Re: Mercer Island Transit Integration Project - Permits and Conveyances

SUBMITTAL REVIEW COMMENTS		Page 1 of 16
AE 0072-19 Mercer Island Transit Interchange		
Submittal No./Ref./Title: 90% Submittal	Date Received: 9/18/2020	
AHJ: City of Mercer Island	Date Due: [Due Date to Contractor]

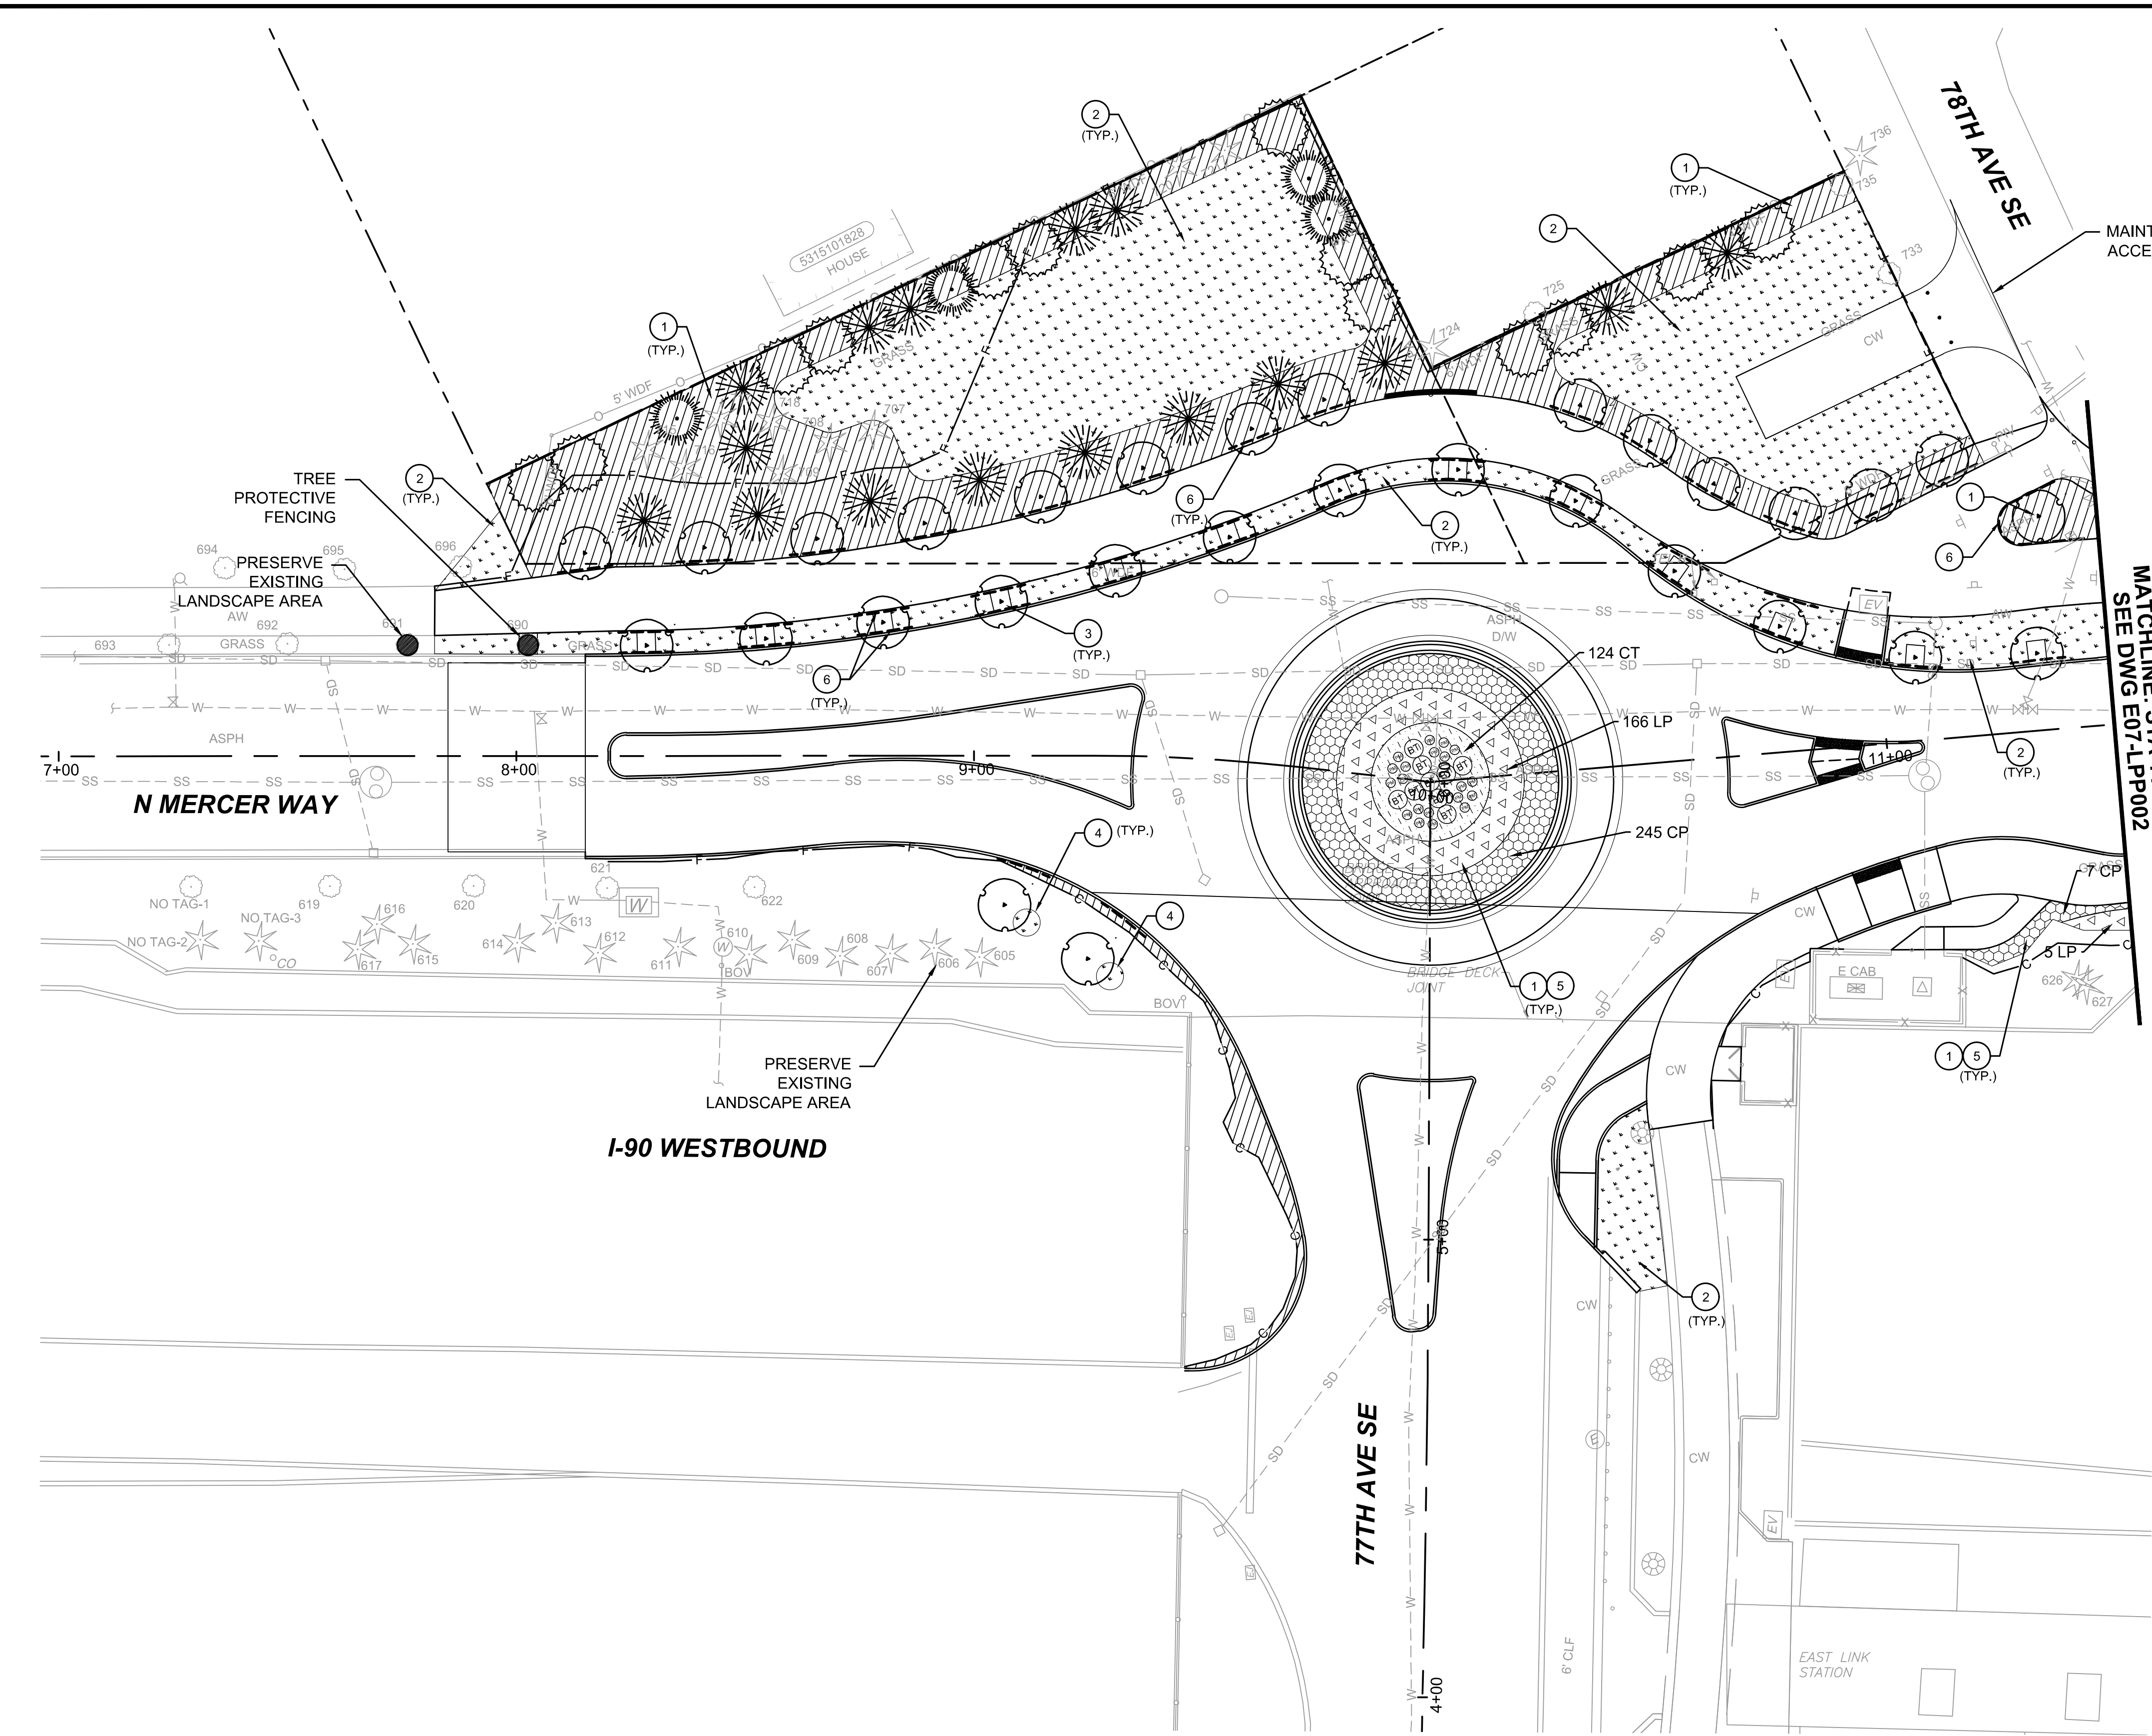
PK 2	90% Plans	11	AS/P W	Trees 603 and 604 on the SW corner of 77 th & NMW need to be removed. They are shown as replanted on Sheet 87.	Removed trees.	AD
PK 3	90% Plans	13	AS/P W	Note 11 says to replace root barrier wherever found during construction of curb ramps. Request that this be expanded. Note would read "Contractor to mark up plans with locations of root barriers wherever found during the demolition of the existing trail. Contractor to replace root barrier with new barrier along the new trail location as specified prior to paving."	Will incorporate.	AD
PK 4	90% Plans	19	AS/P W	Note 8: we have no knowledge of a gravel base course being an adequate root zone protection measure. Please remove.	Removed	AD
PK 5	90% Plans	41	AS/P W	The irrigation controls have Note 2 "relocate existing utility" applied to them. We request a new note specific to irrigation. That would include "contractor is responsible for supplying adequate water for plant growth to irrigated landscapes when irrigation is disconnected for more than 48 hours."	Will incorporate	AD

DRAWING No.:  
**E07-CRY002**  
LOCATION ID:  
E07  
SHEET No.:  
9 OF 104  
REV:  
0

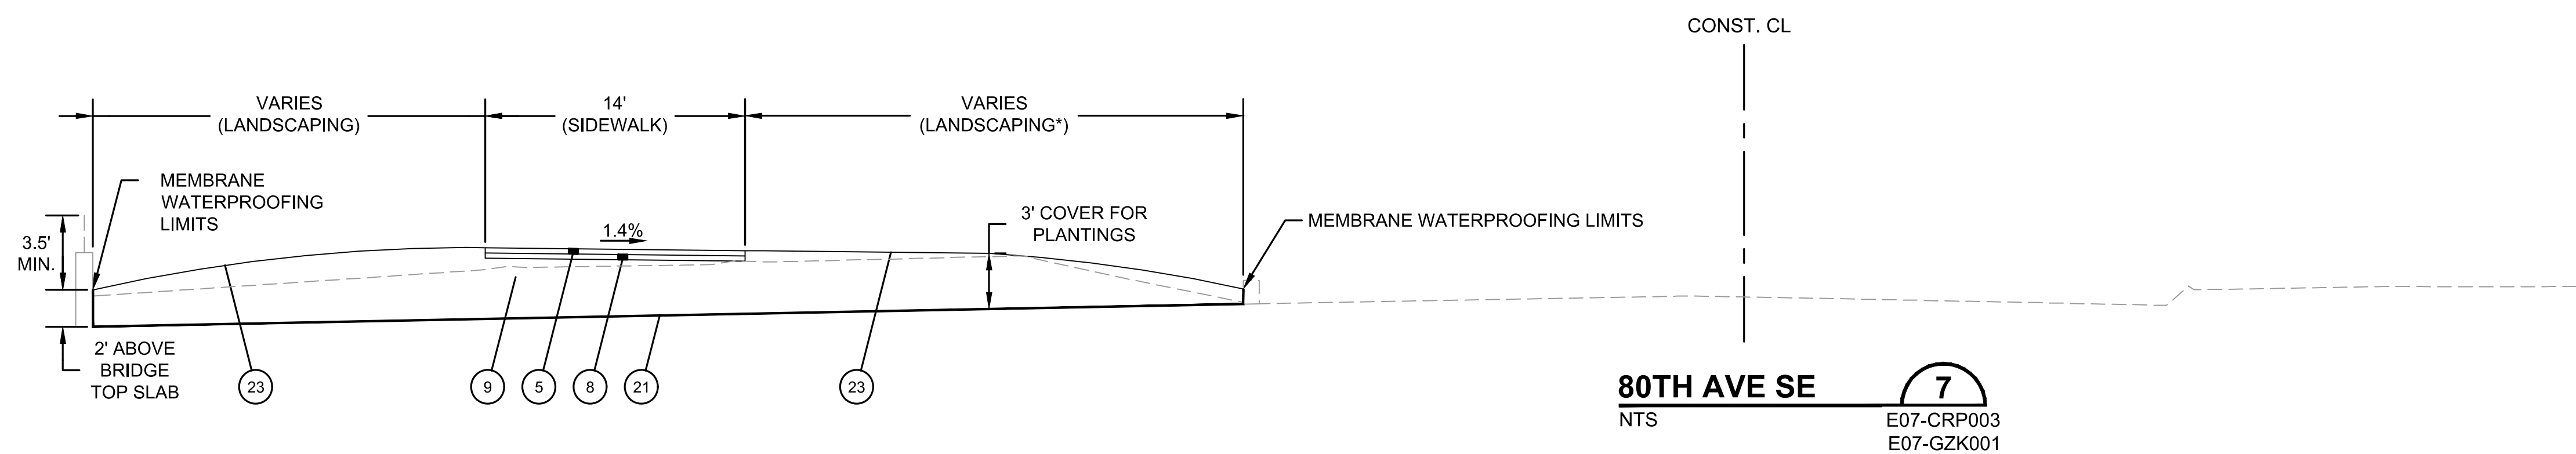
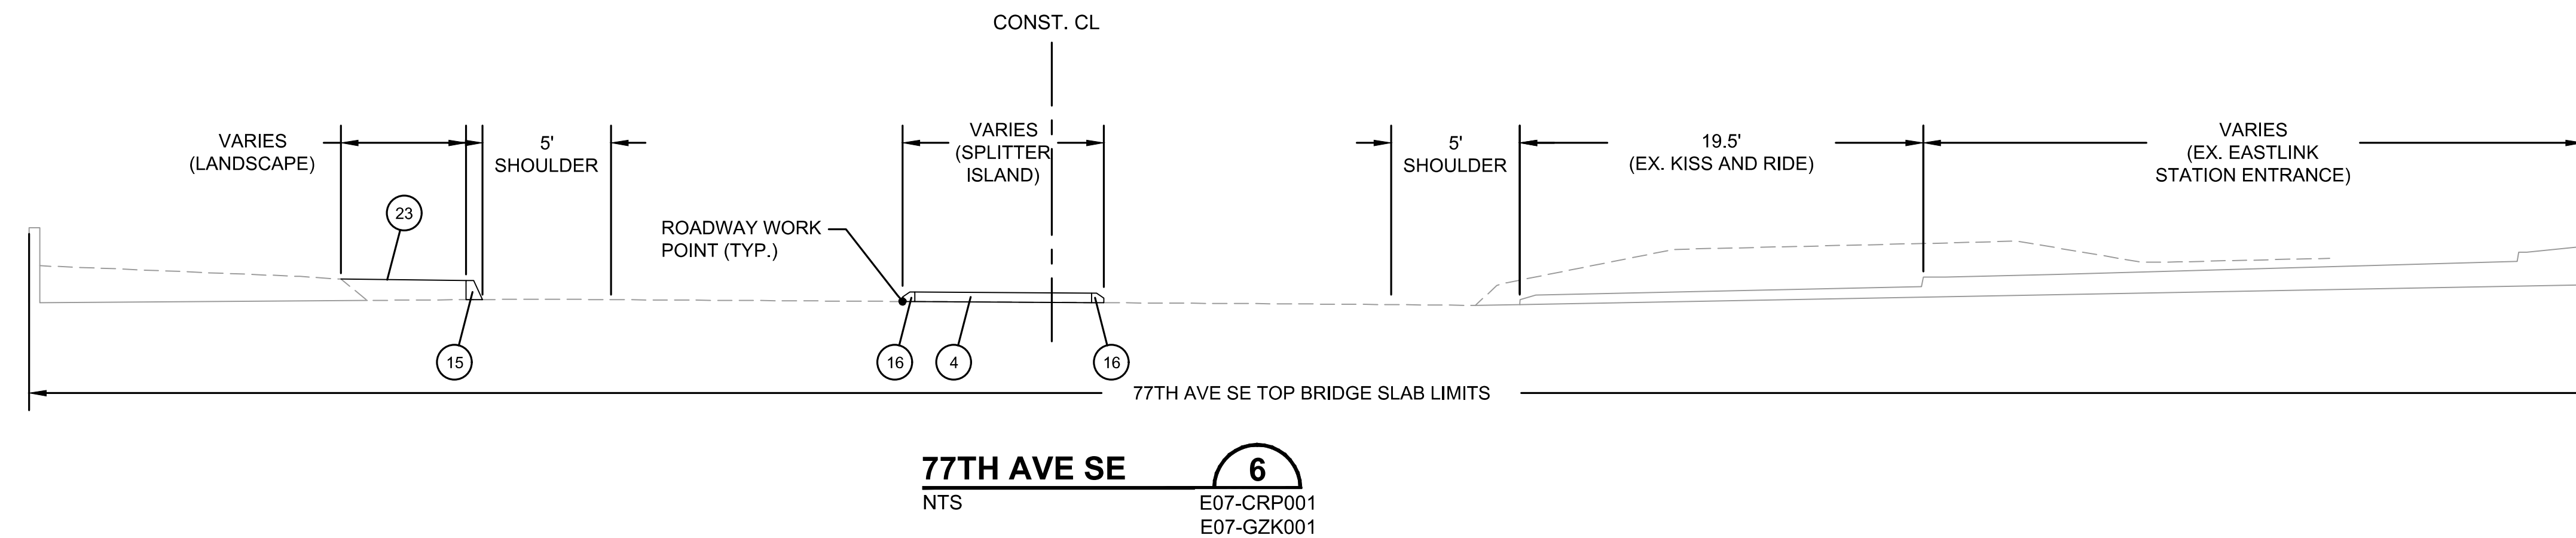
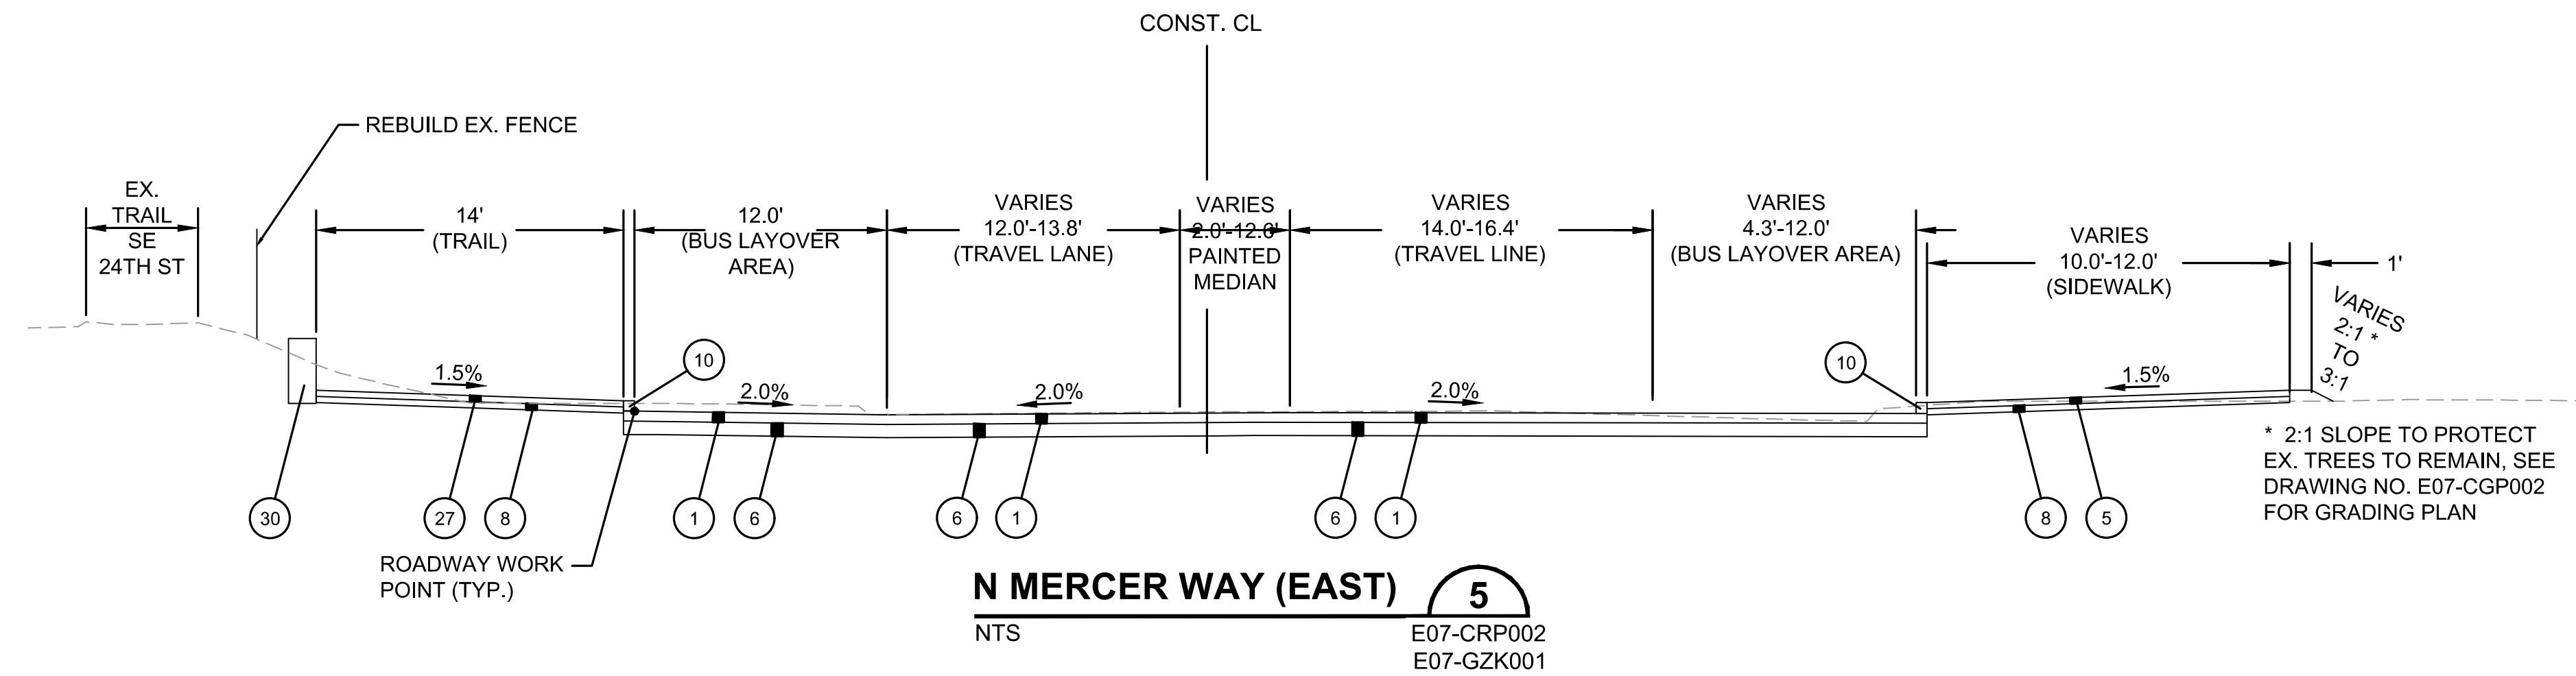
PW1	90% Plans	9/92 CRY002	TRF	60% - PW 5 comment has not been addressed in the 90% design. The plan views (e.g. CMP001) correctly shows the west side (southbound) bike lane on 77th Ave SE. Revise cross-section to be consistent with the plan view.	Will revise.	AD
PW2	90% Plans	12/96 CXP002	TRF	60% - PW 6 comment has not been addressed in the 90% design. Include in the site prep a note to remove the FH at approx. sta 11+52 north side. Since FH relocation is noted on utility plan, add note to Site Prep to relocate per UCP001.	Utilities are not within site prep/Demo plans. General note references UCP sheets for utility relocations, which include fire hydrant notes.	No Change
PW3	90% Plans	13/96 CXP003	TRF	Site prep note for 17 is missing or labels should be numbered 3.	Revised.	AD
PW4	90% Plans	15/96- 16/96 CTP001	TRF	60% - PW 9 comment has not been addressed in the 90% design. Add inlet protect for other CBs just outside the 'project limit' but potentially impacted by runoff. These include: <ul style="list-style-type: none"> • 80th Ave SE at 4+75 LT on east side. • 77th Ave SE within 'kiss-n-ride' • 77th Ave SE at 4+40 on west side near ramp. 	<ul style="list-style-type: none"> • Lid slopes towards west side on 80th so structure on east side is "uphill". • Do not see CB here- jbox? • Structure is in landscaped area outside of project limits – no need as no work in this planter area. 	AD
